From: Finlay Gardner
Sent: 04 June 2019 12:02
To: Lynnyrd Wolfe
Subject: FW: A/51/19/HH - Milner Cottage, The Thatchway, Angmering
Attachments: 1197.01.a Existing and Proposed A1.pdf

From: Lauren Willard <[REDACTED]>
Sent: 03 June 2019 12:02
To: Finlay Gardner <[REDACTED]>
Cc: Planning <[REDACTED]>
Subject: A/51/19/HH - Milner Cottage, The Thatchway, Angmering

Drawing Number: 1197.01.a

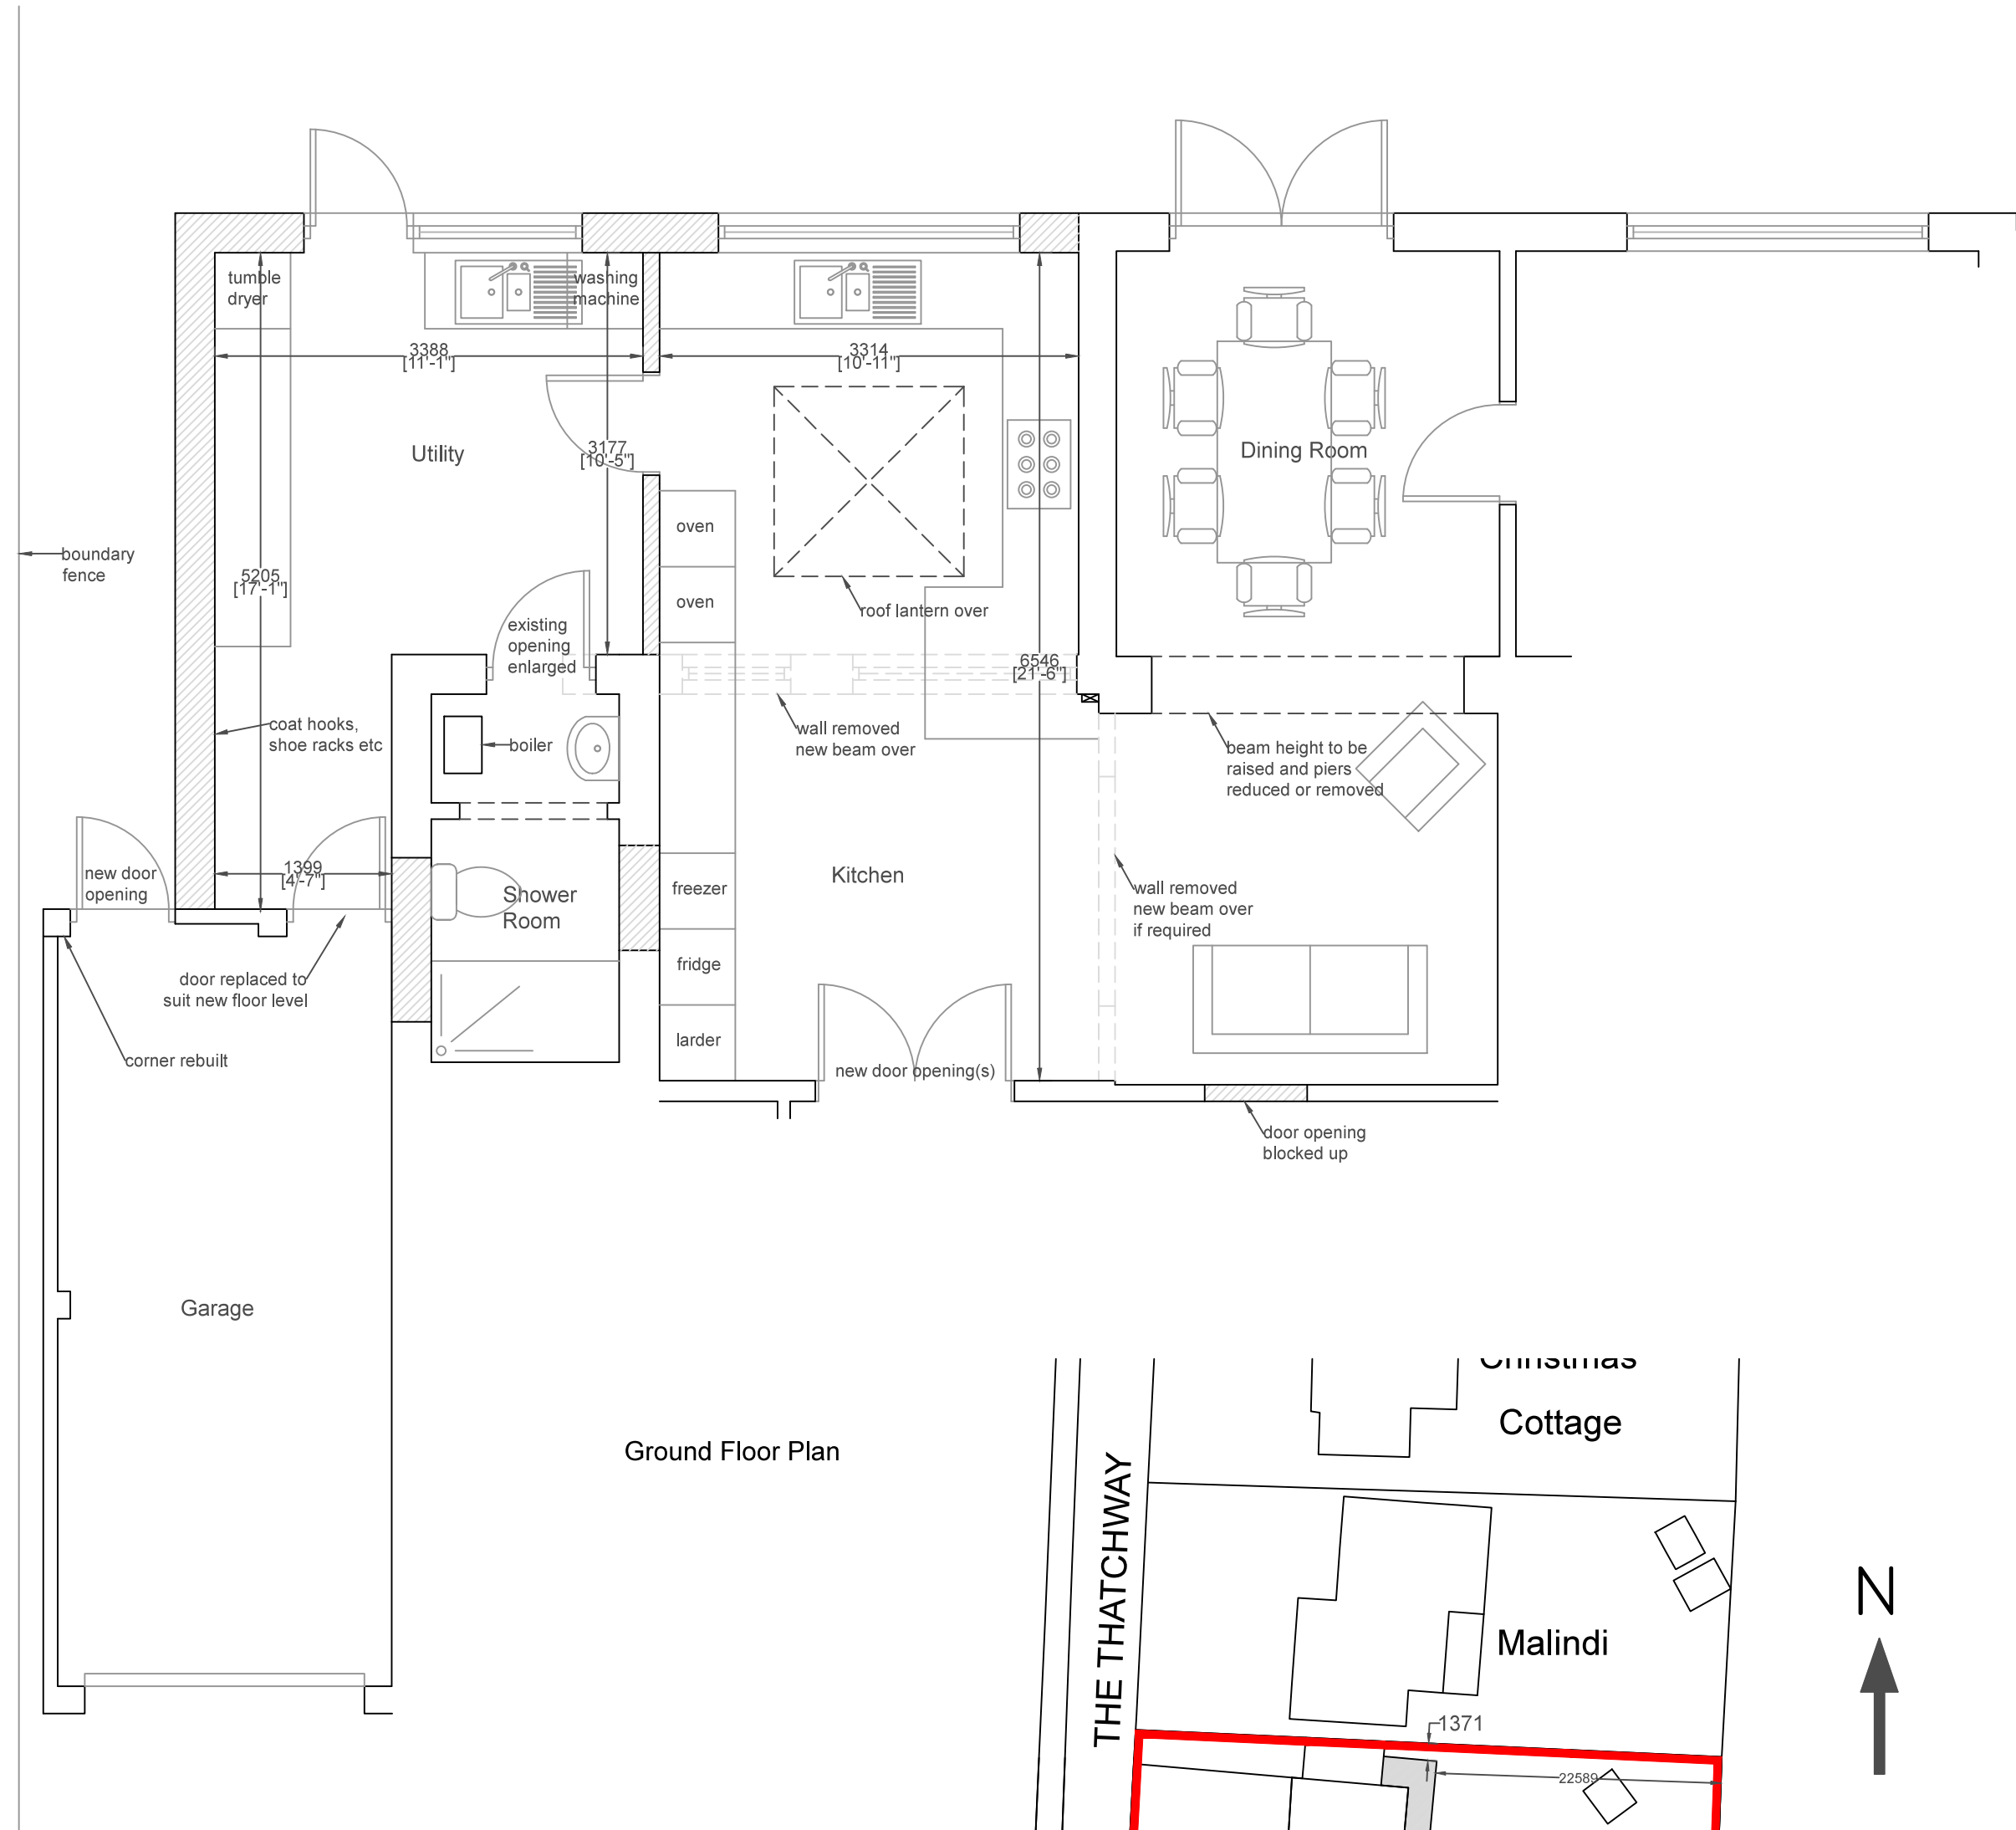
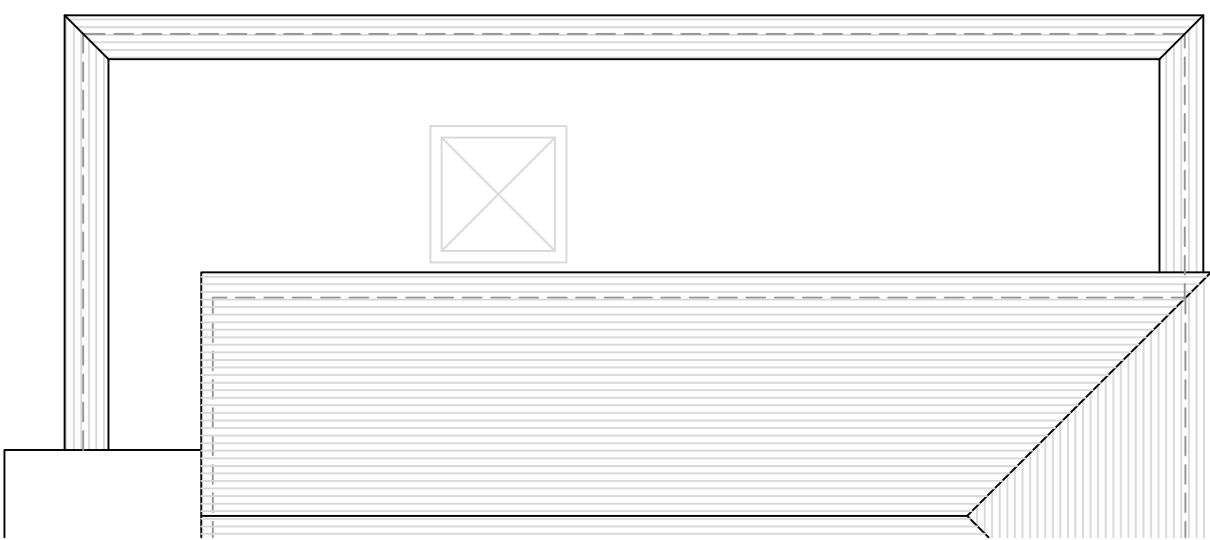
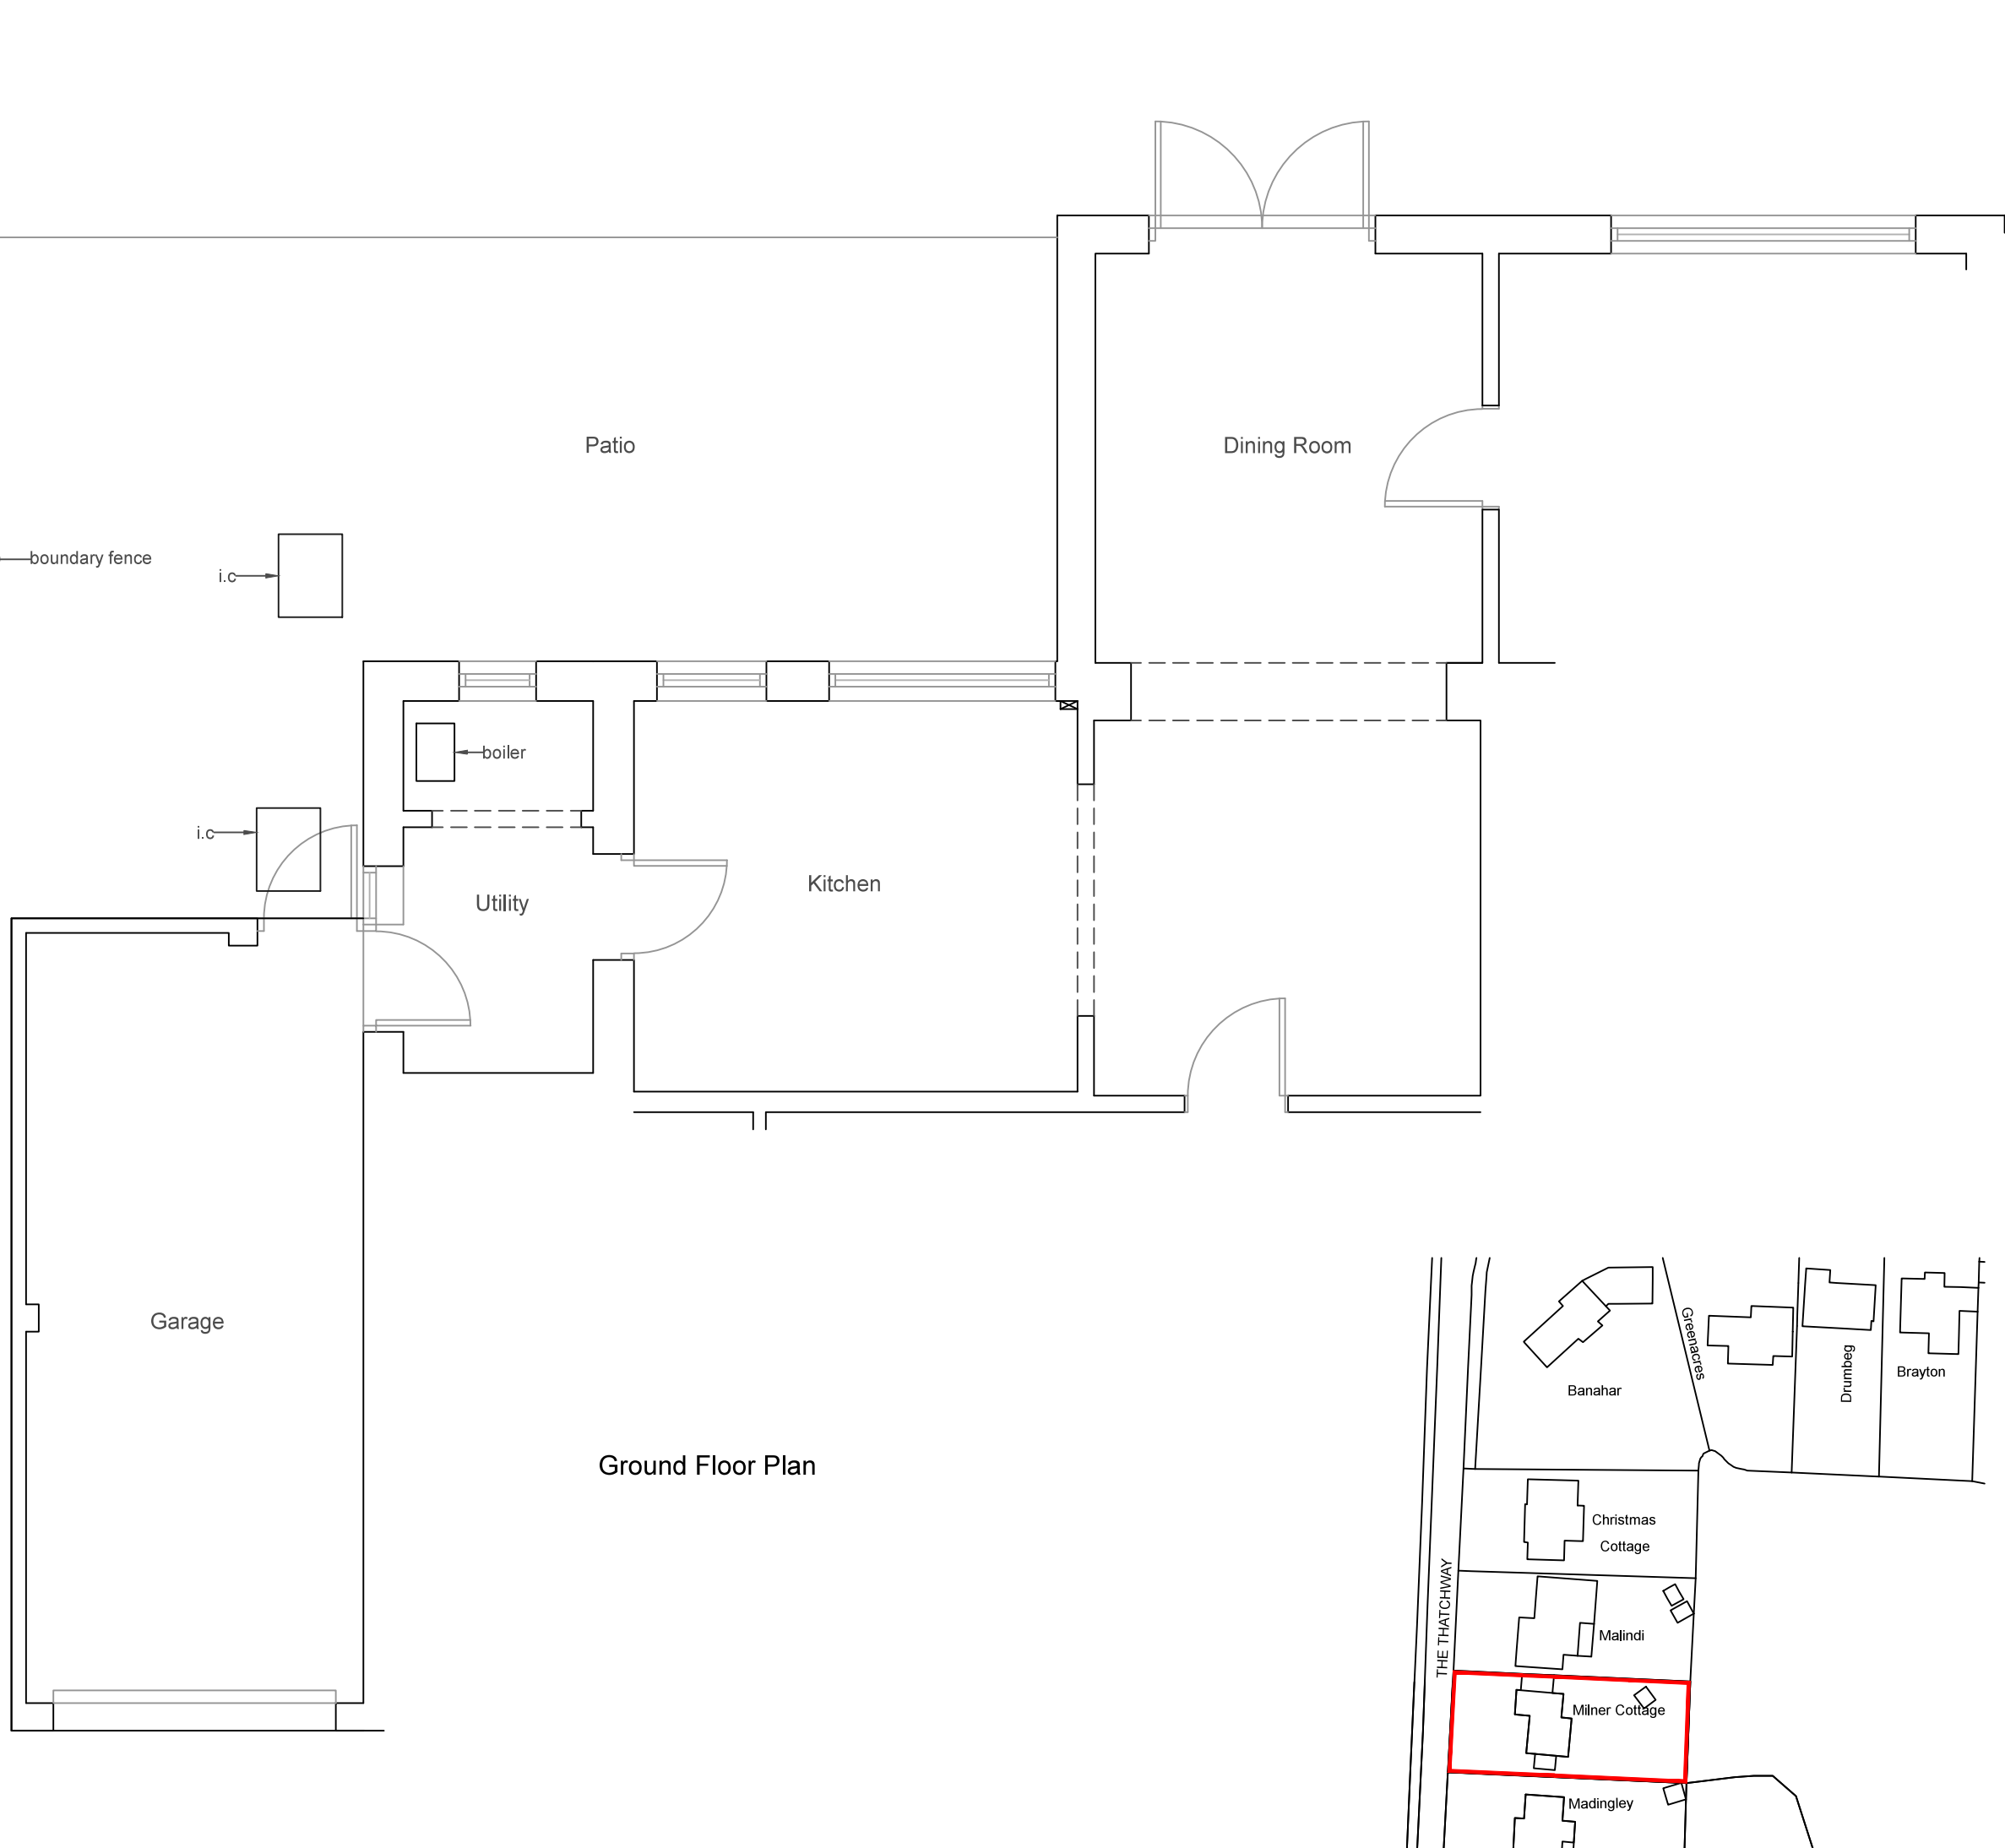
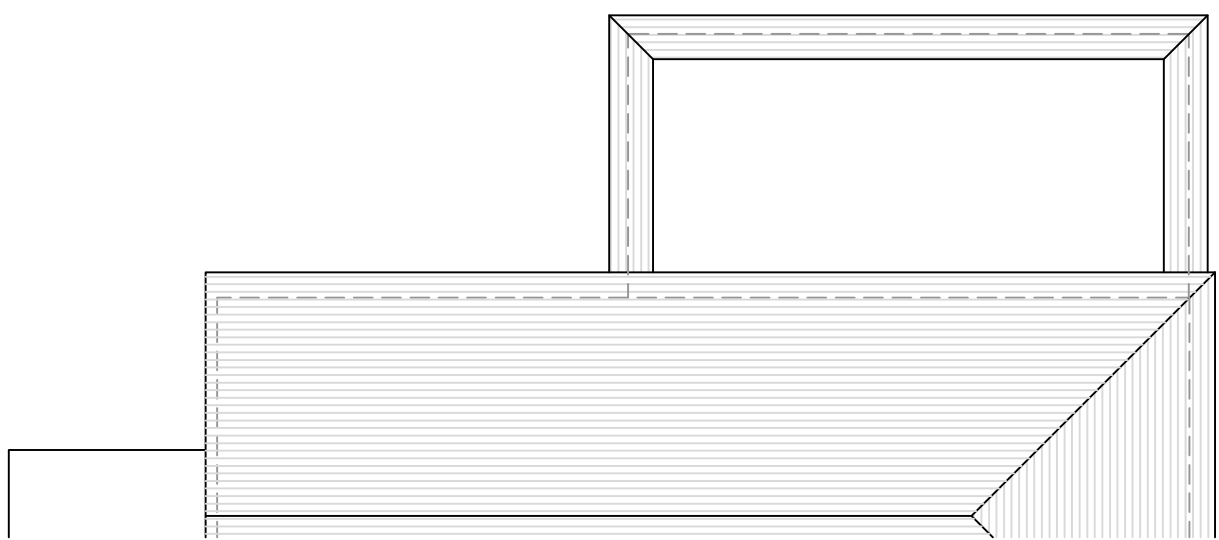
Please find attached an amended drawing I would like to substitute for the one previously submitted for approval. The only amended to the drawing is the addition of a roof lantern in the flat roof of the proposed extension.
